Application no: H11/0949/00

Description: Conversion of barn to form
additional residential
accommodation

Location: Red House
Jarvis Gate
Sutton St. James
Lincs

Amendment: Revised curtilage and alterations to fenestration
(Dwg nos.SH/62400A & SH/61600B)

| Drng no. SH/61600 ^                                                                                                            |         |                                                                                                        |       |

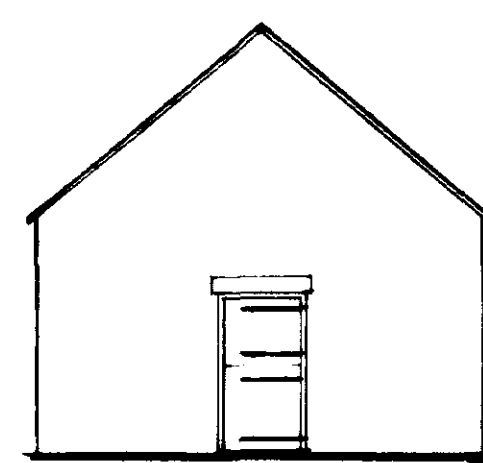
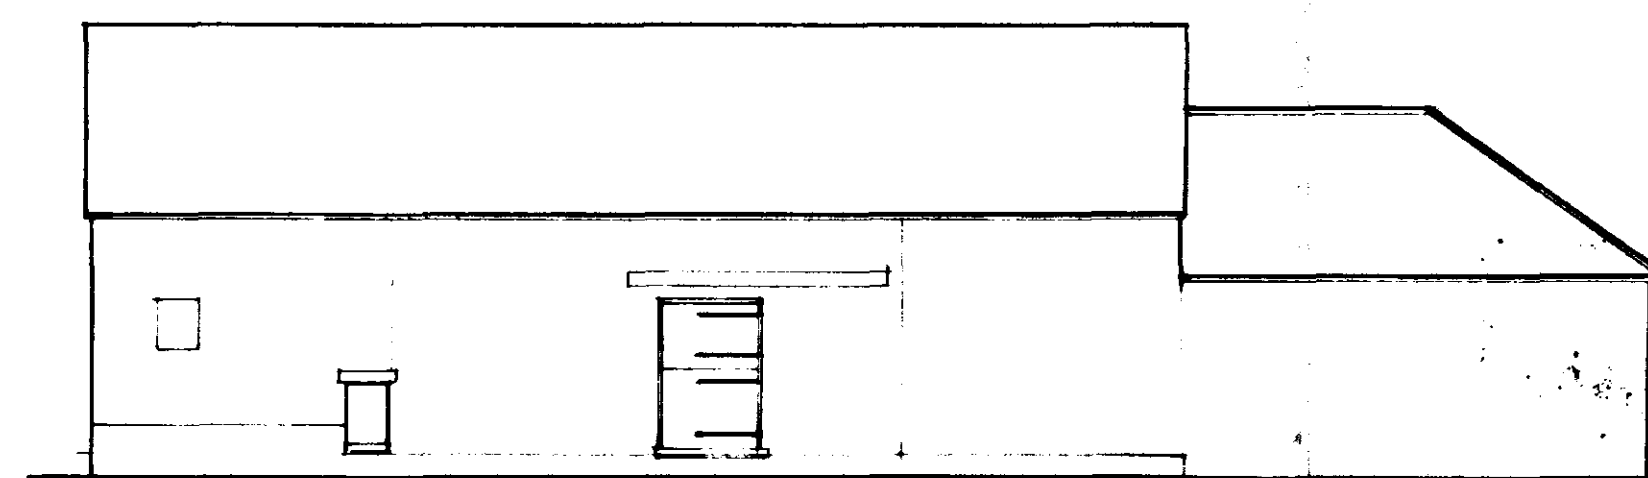
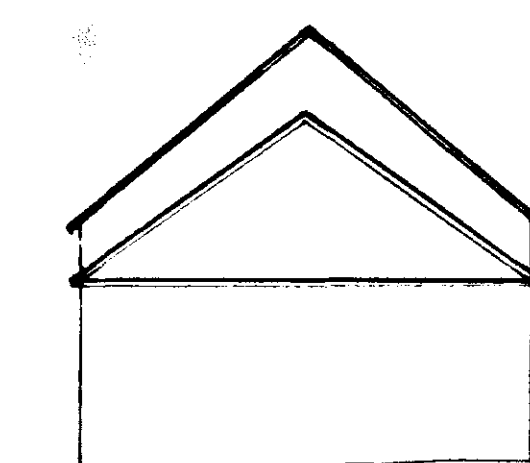
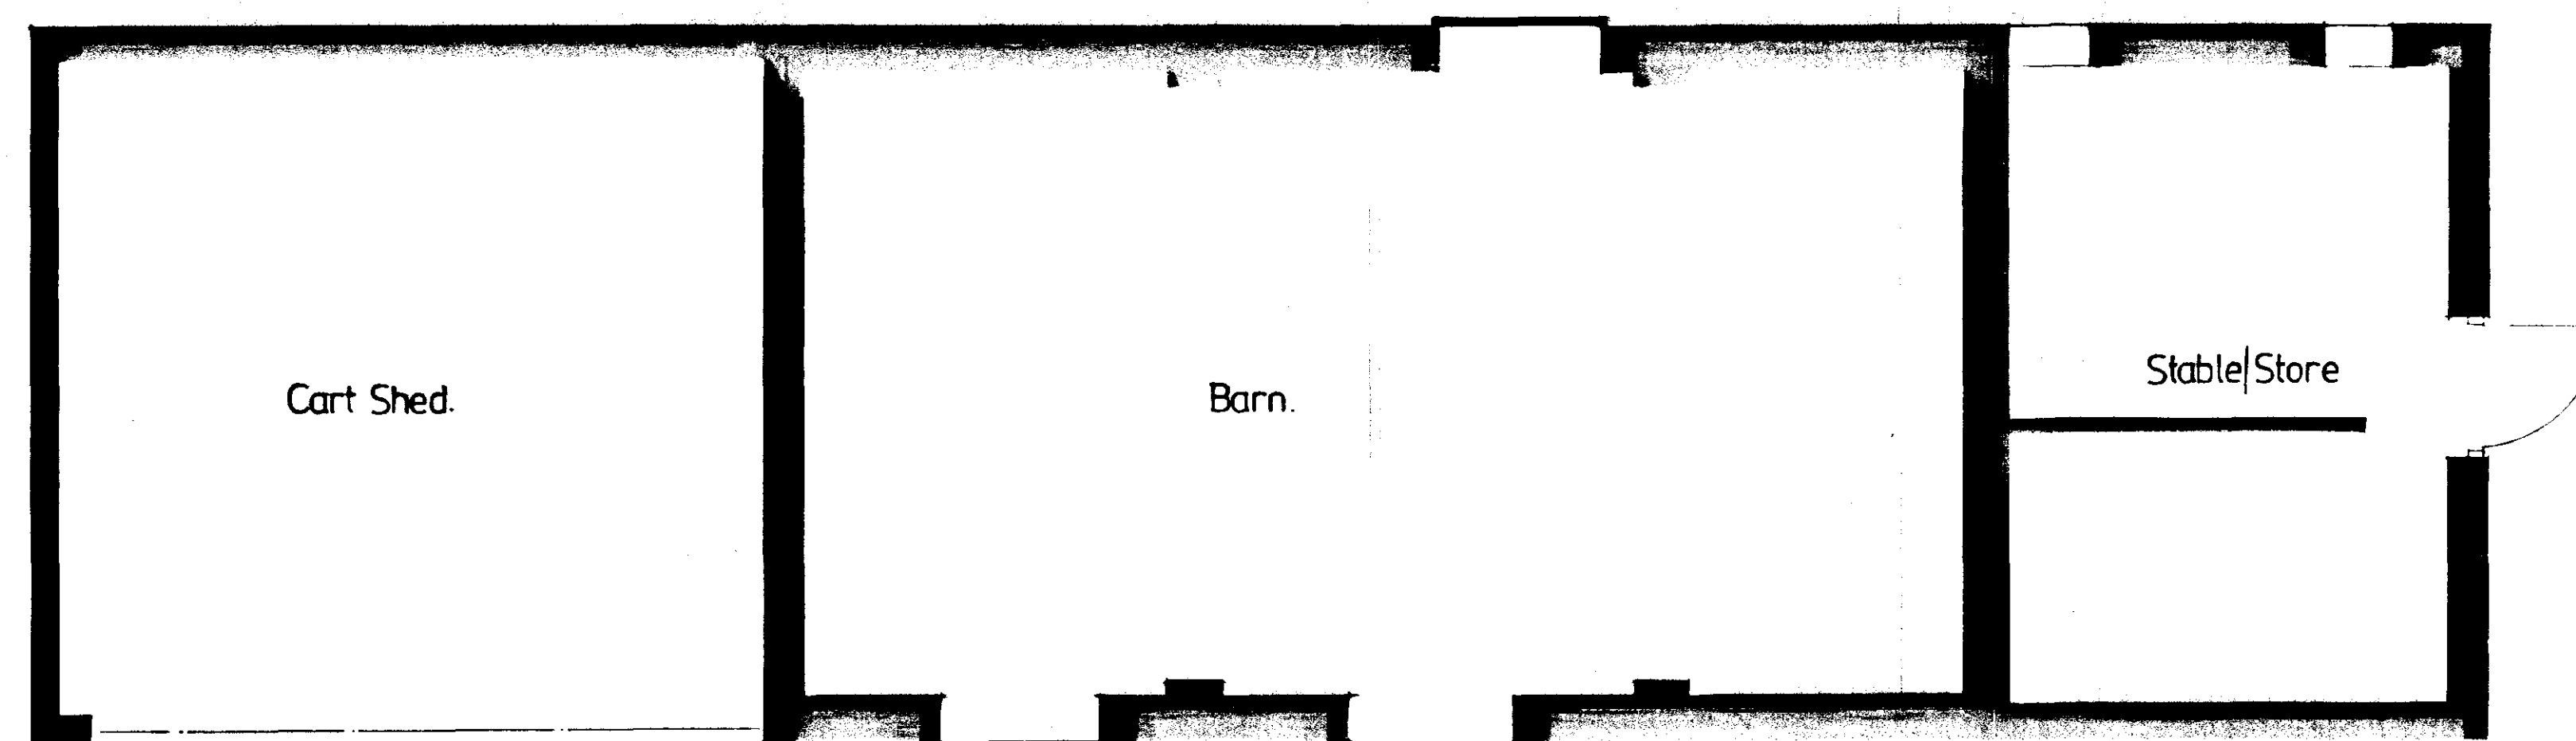
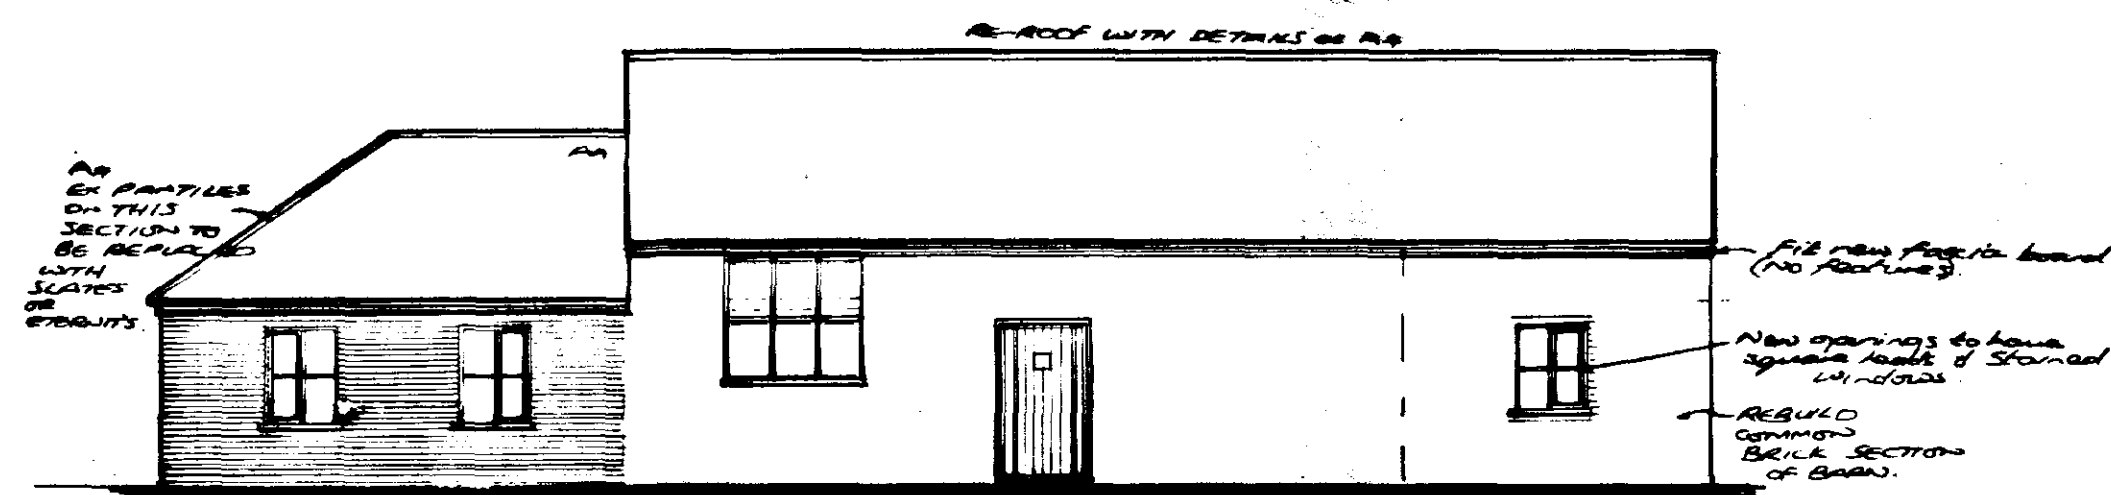
1. Details of eaves and doors/windows added to plans. These are basic details as no major details are envisaged.
2. The windows have been amended and my Client is in agreement to stain windows and doors.
3. This Building will be an annexe to the main dwelling and used in connection with Red House.
